Salesbury Parish Council

RE: Planning Application 3/2016/0333 Blue Trees, Copster Green, BB1 9EP

Salesbury Parish Council object to this planning application and make the following observations:-

Drawing  
Proposed Garage and fence details  
Date January 2016 Drawn by Craig Buck Scales 1:50+200 @ A1

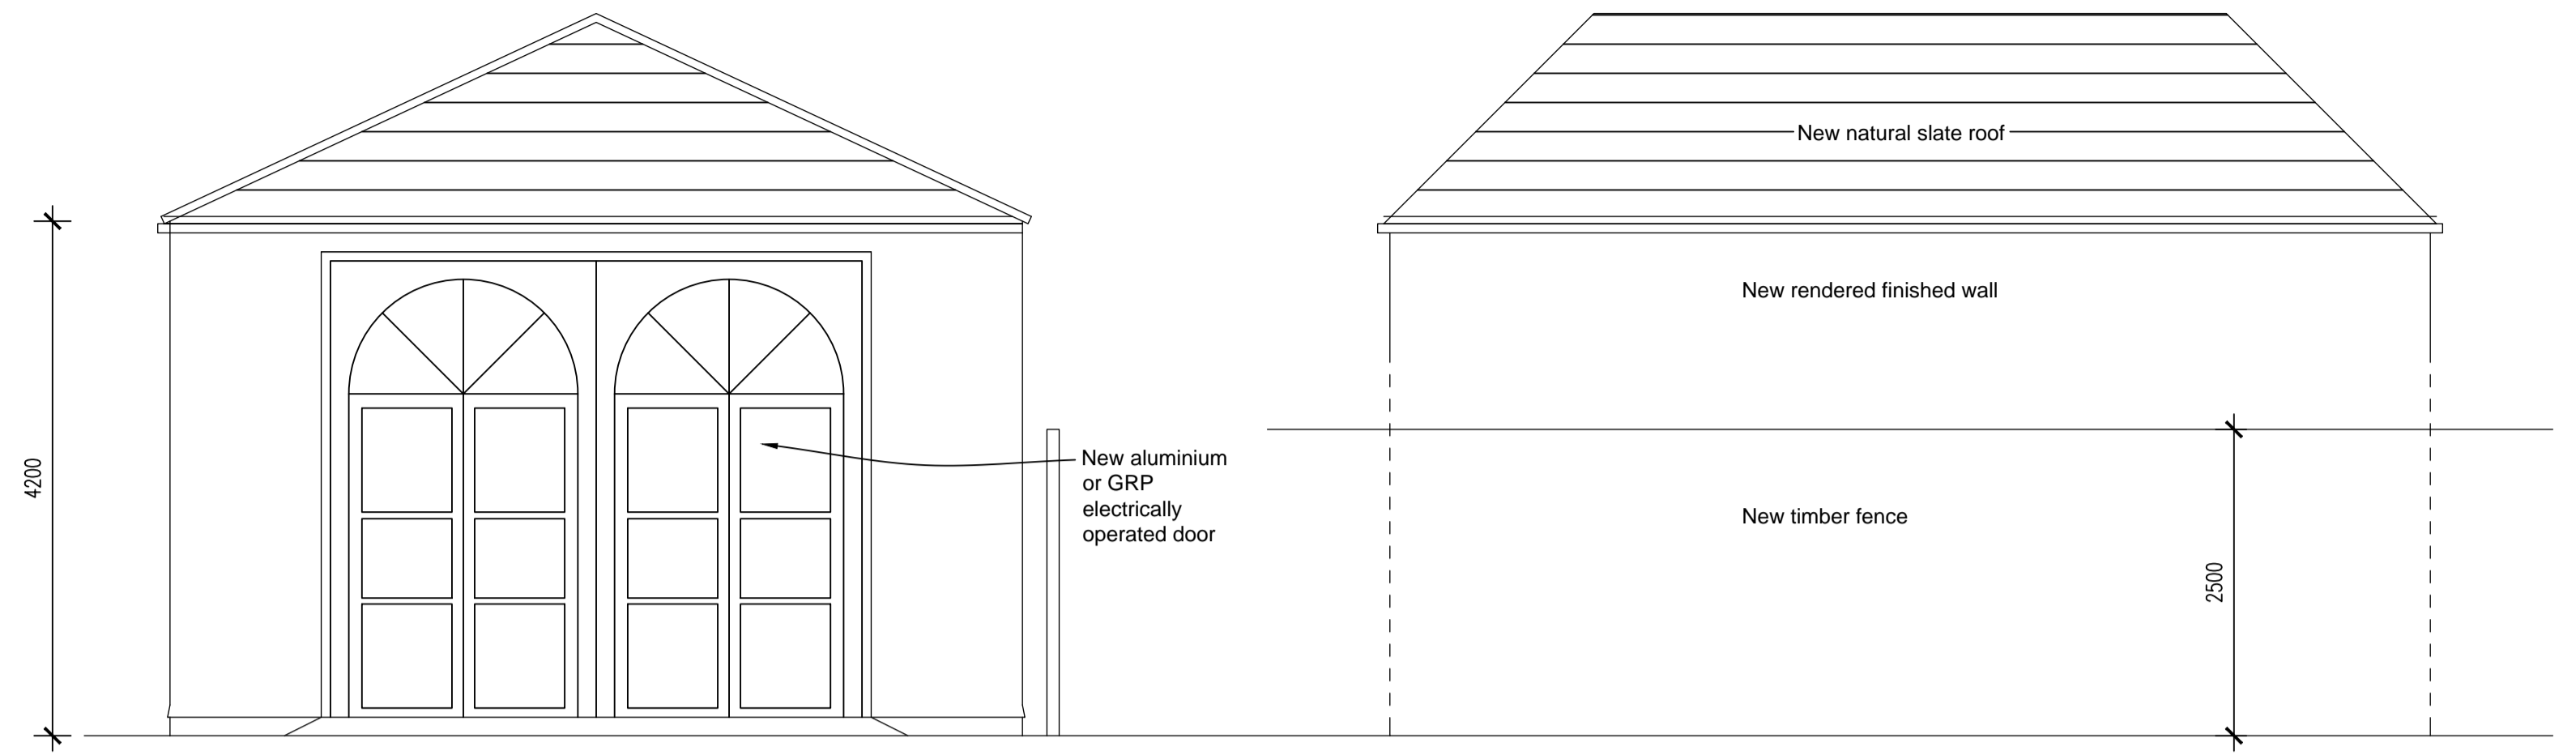
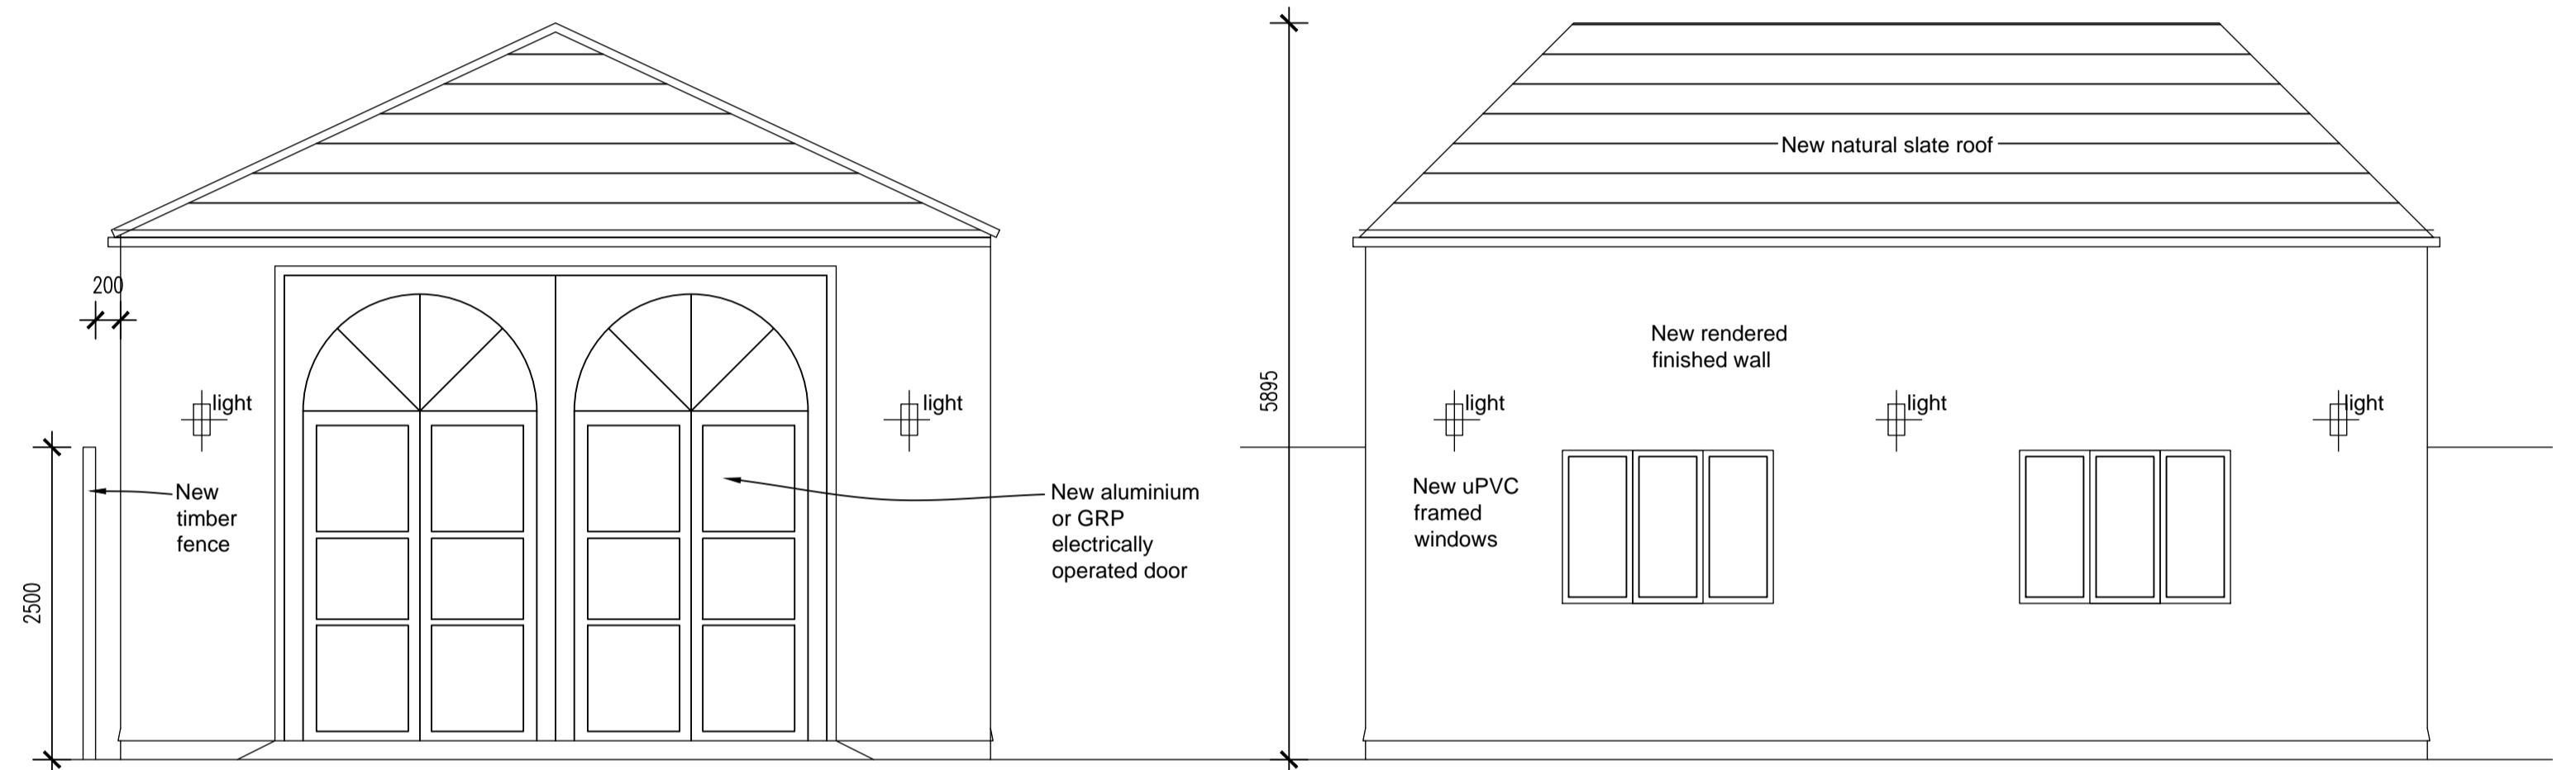
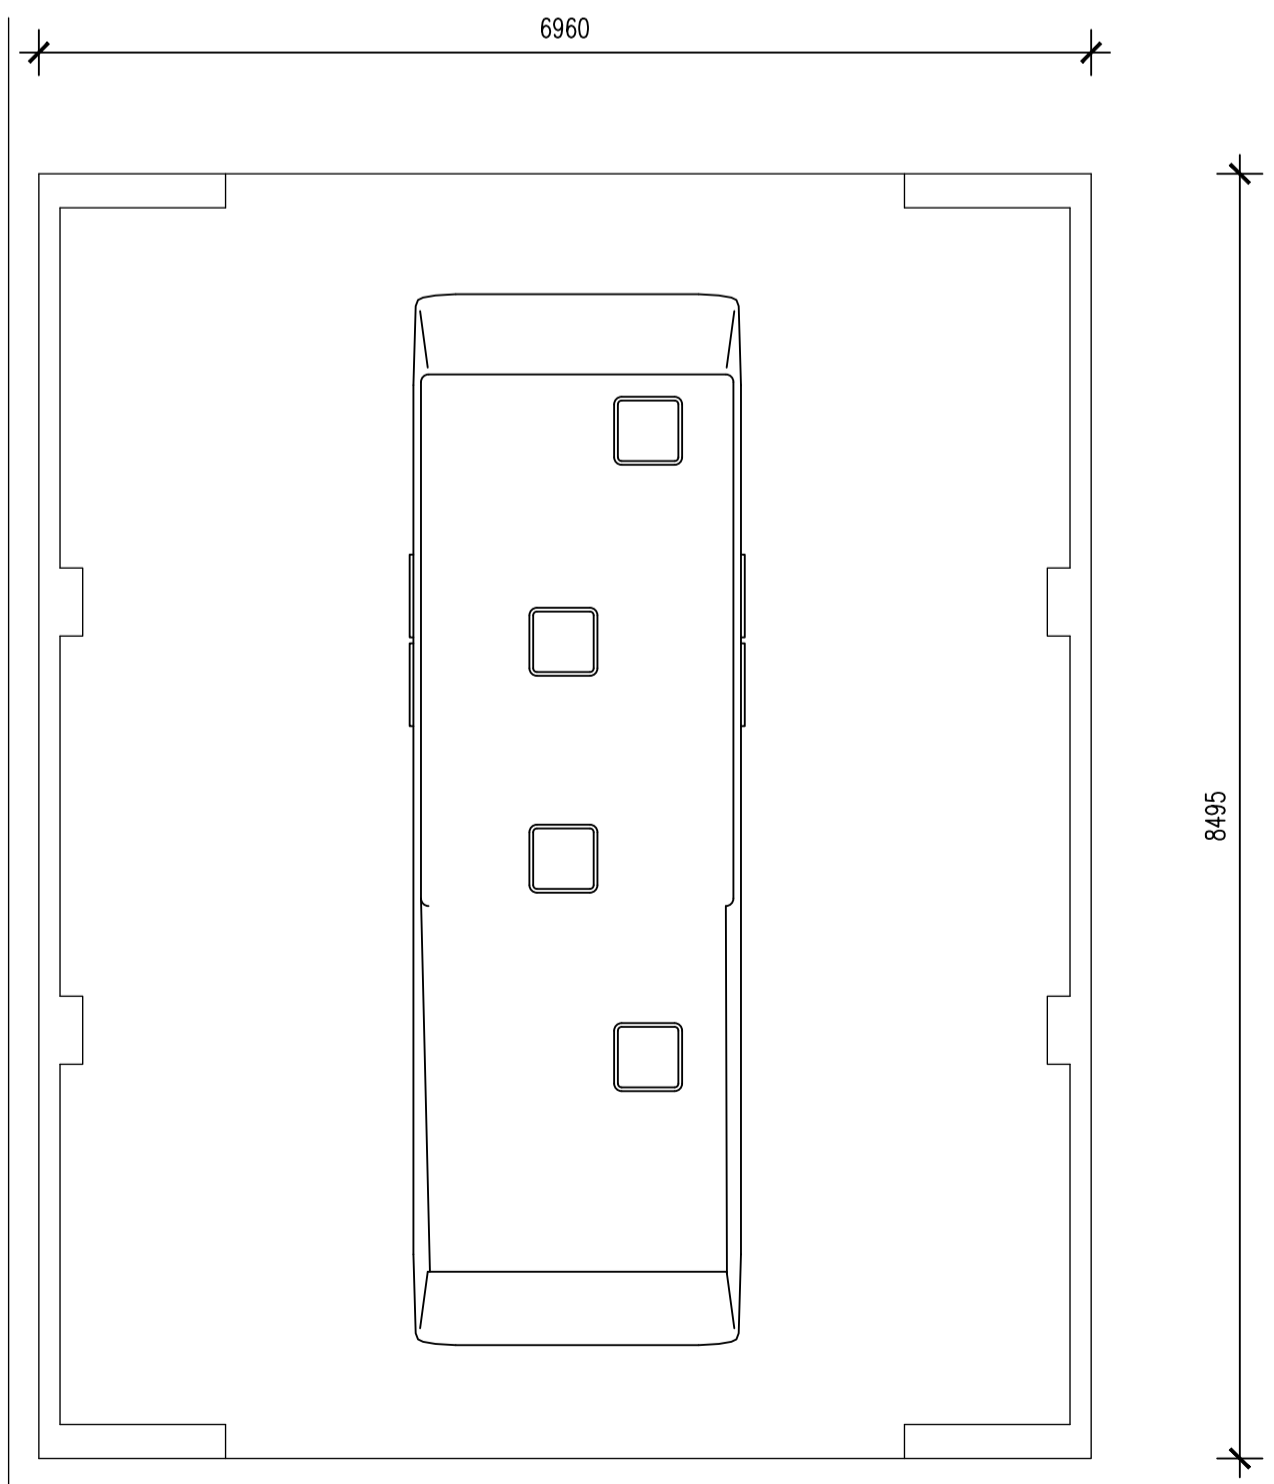
- There appears to be no design submitted for the extremely high boundary fence (8ft plus height reduced from 10ft plus)
- The design of the intended caravan has increased in size
- The profile of the roof has changed with yet again major dominant impact on the adjoining properties
- The design of the huge doors has changed but cannot be justified. (Should permission be granted this is the first thing that one would apply for a change of conditions in design considerations)
- The proposals are not conducive with the environment or street scene of the hamlet of Copster green
